CITY OF ALBUQUERQUE

December 10, 2025

RE: ALOFT HOTEL
1501 Aircraft Ave SE
Grading & Drainage Plans
Engineer's Stamp Date: 10/30/2025
Hydrology File: M15D057
Case # HYDR-2025-00219

**SECTION D-D RETAINING WALLS**

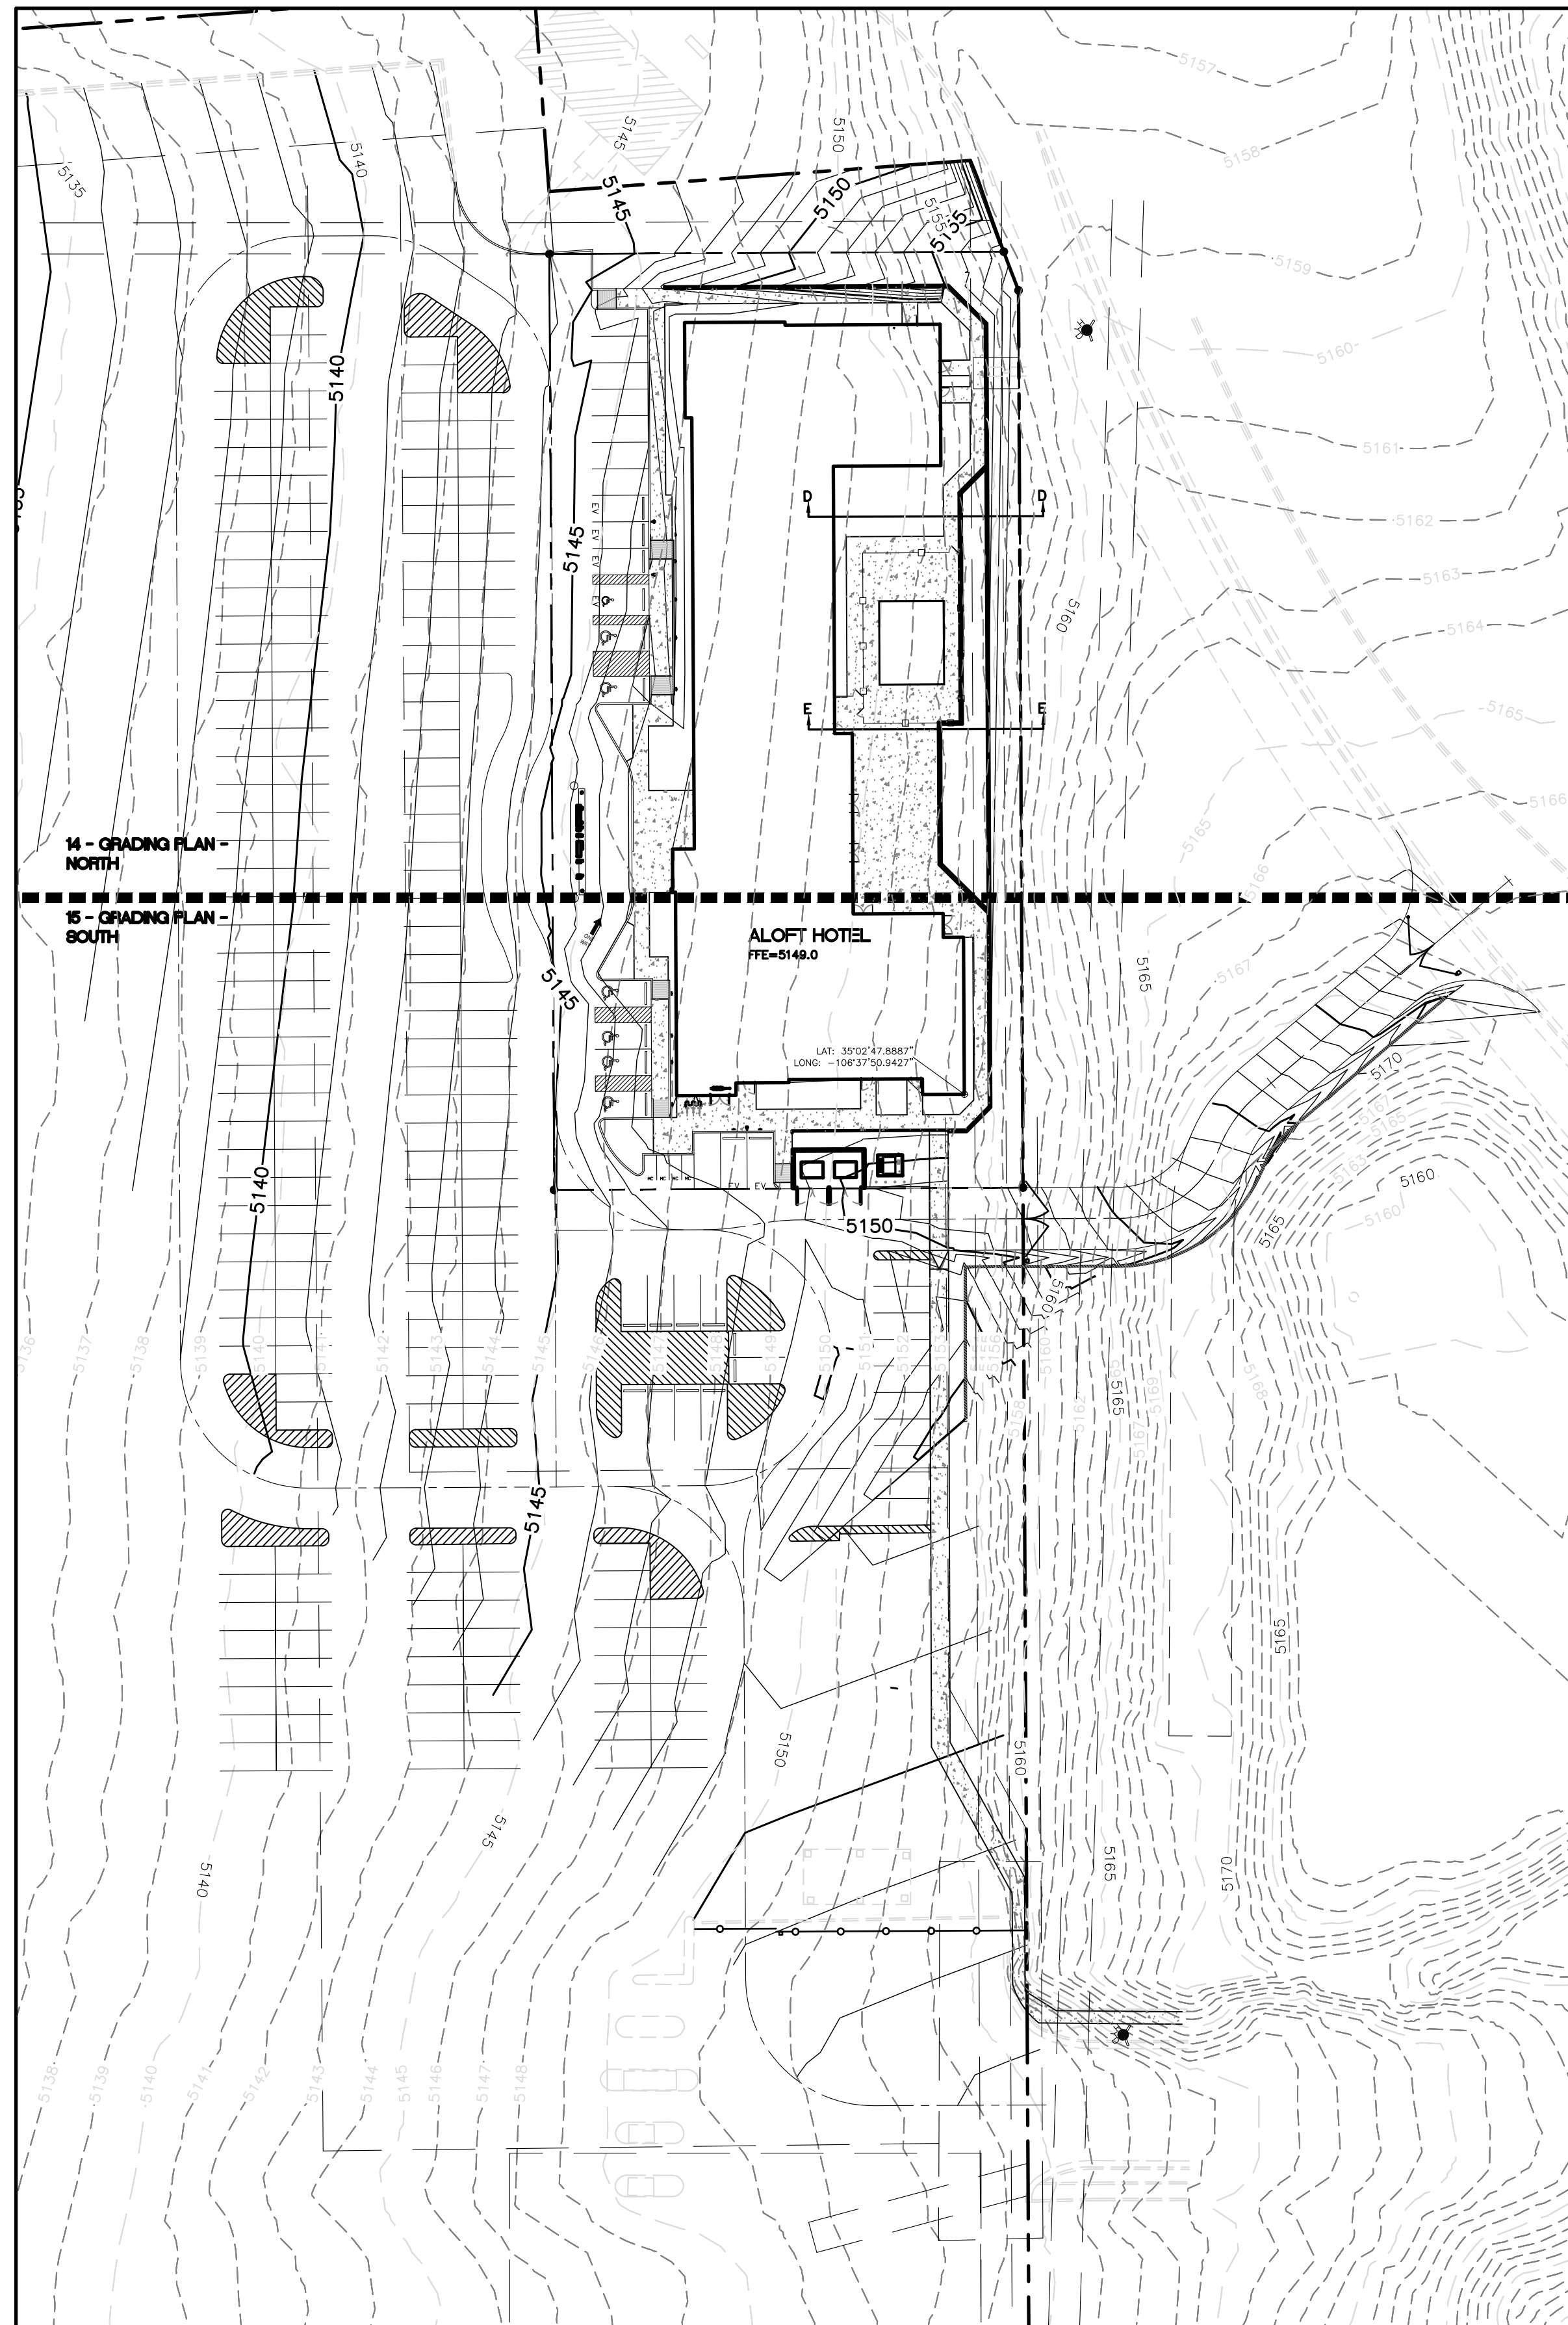
3. Provide details for the retaining wall south of the emergency access road and east of the hotel parking lot.
4. Provide pond storage capacity, WSEL/Free Board analysis for the existing City pond.
5. Add a water block at the University Blvd. connection.
6. The hotel property owner needs to get an access easement from the City and signs a maintenance agreement with the City.

14 - GRADING PLAN - NORTH

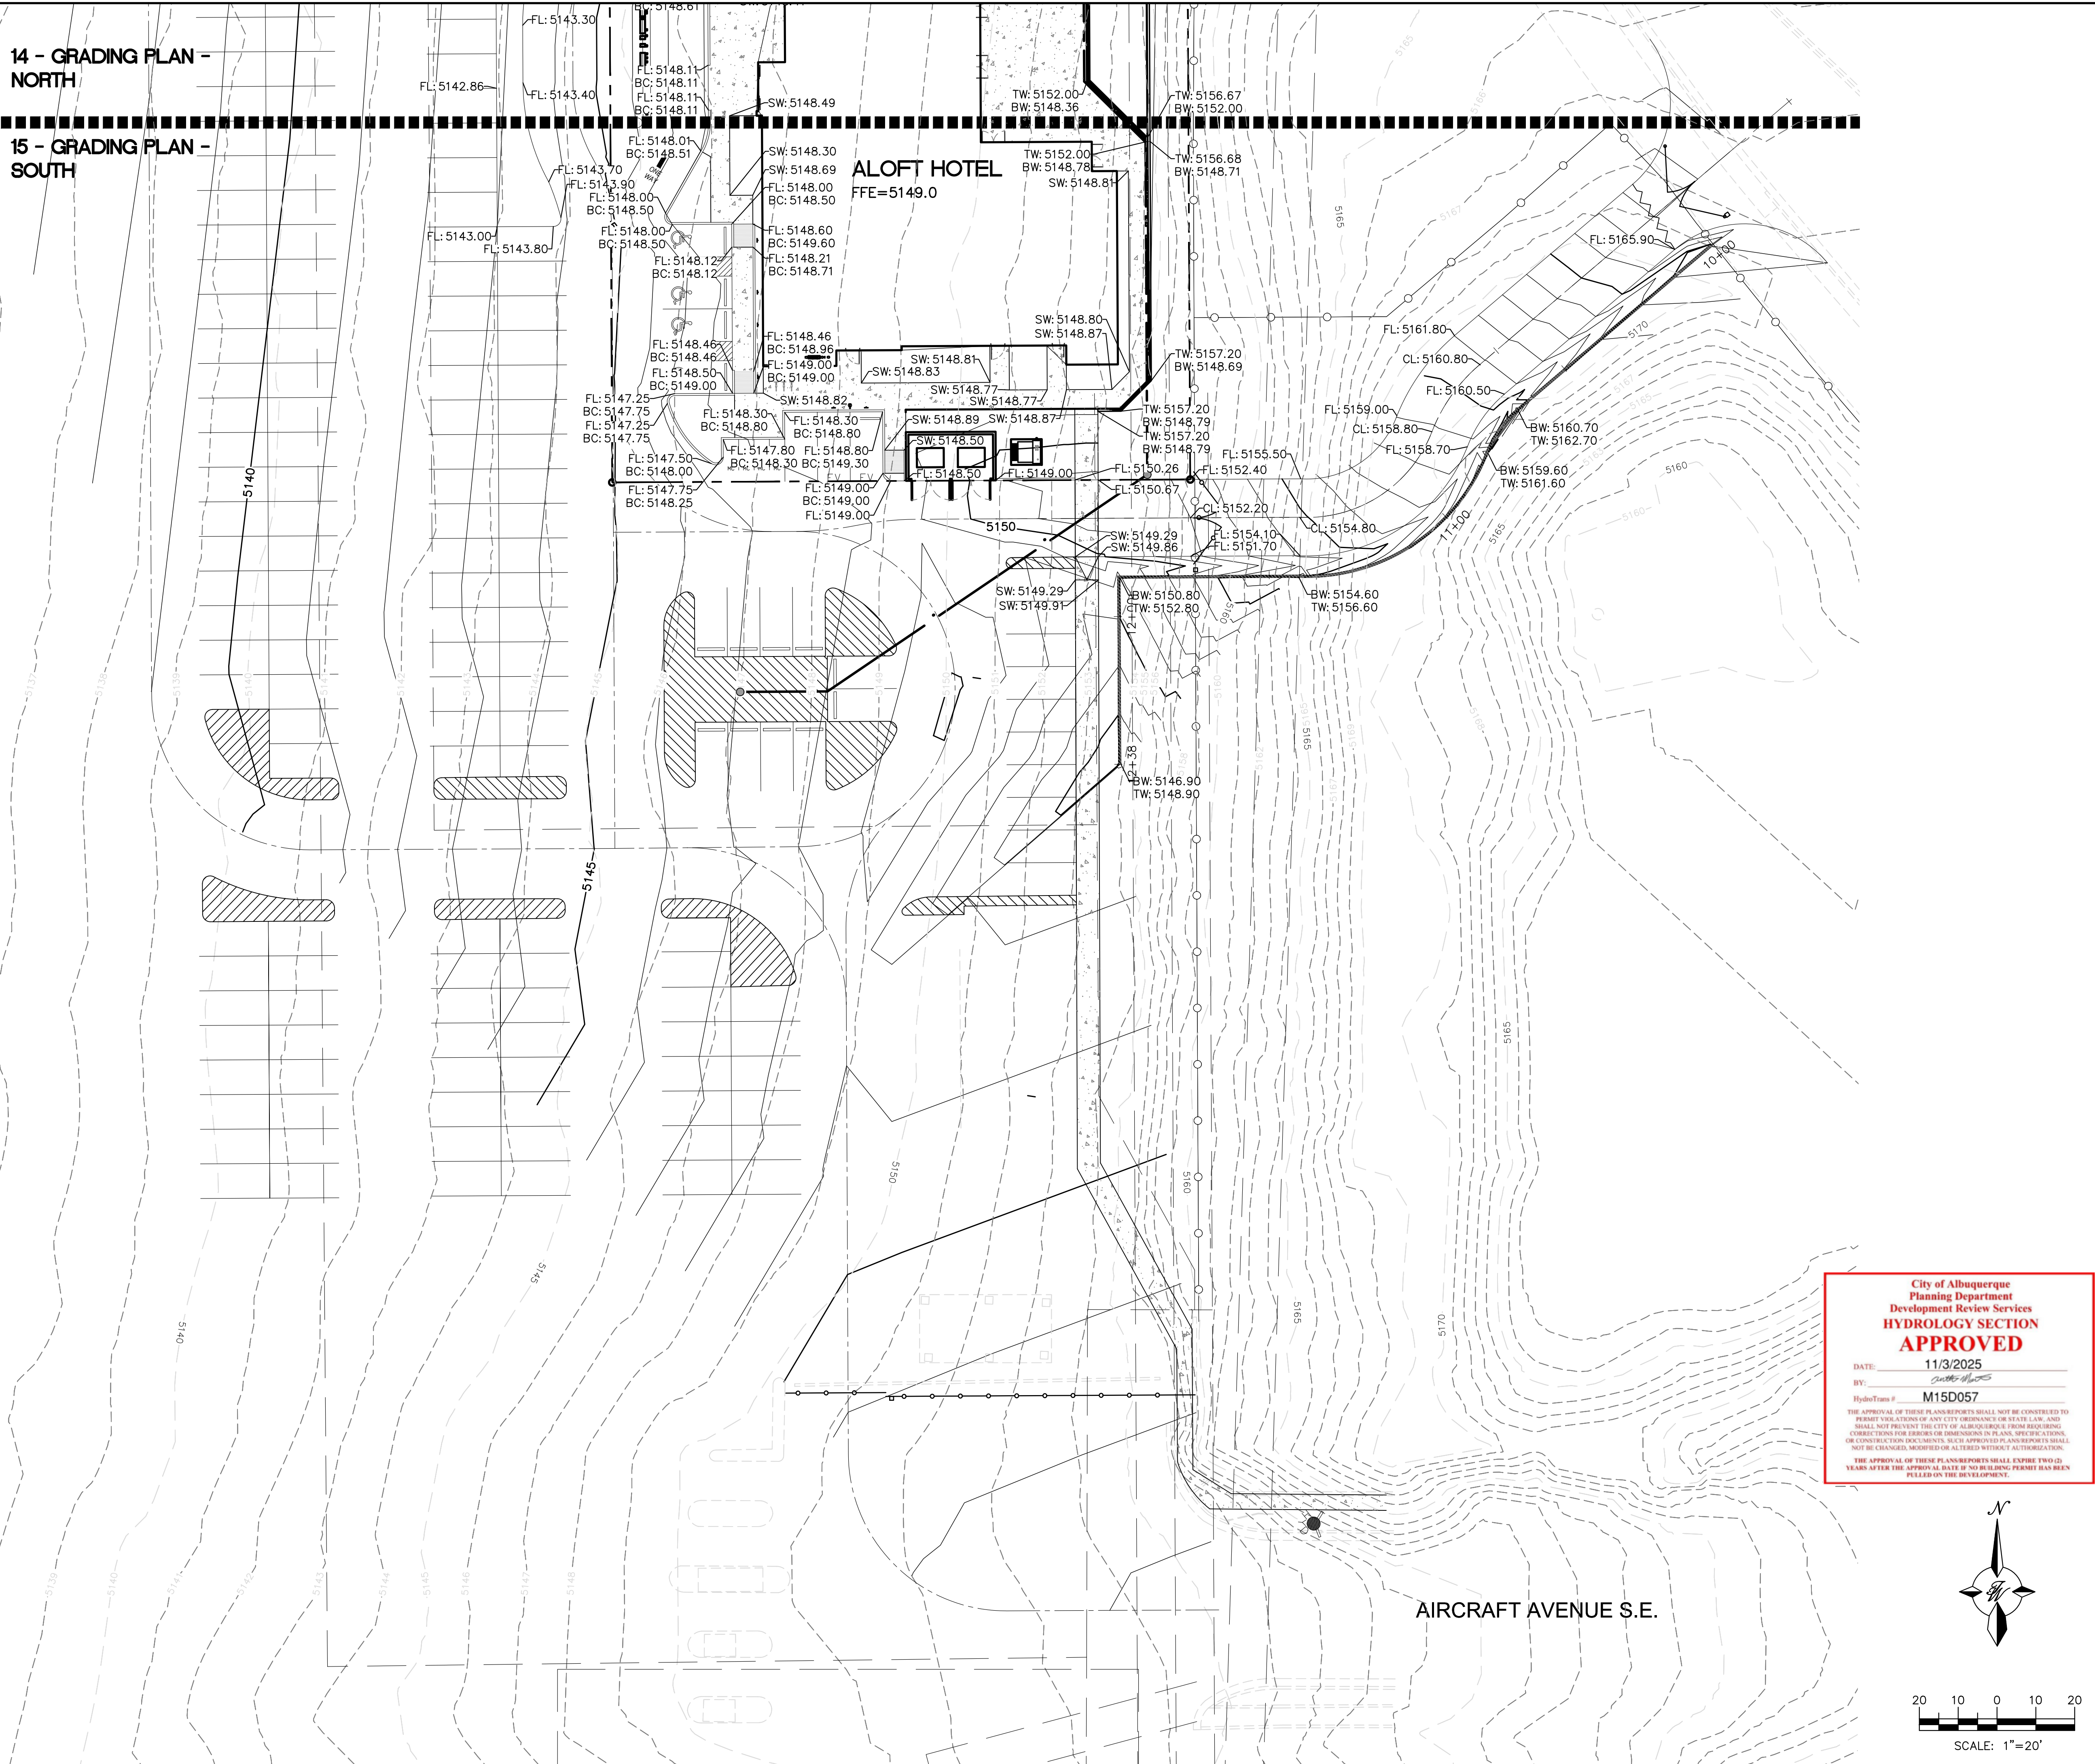
1. The proposed contours on the bottom of the emergency access road east of the hotel show 15' of excavation on top of the existing city-owned dam, which will result in excessive off-site stormwater entering the Hotel construction area with the removal of the dam. The proposed contours don't tie into existing contours, leaving a 15' high slope unaccounted for. The limits of disturbance can't be identified until the proposed contours are tied into the existing contours. Please submit a revised G&D Plan showing the corrected contours to Hydrology for re-approval.
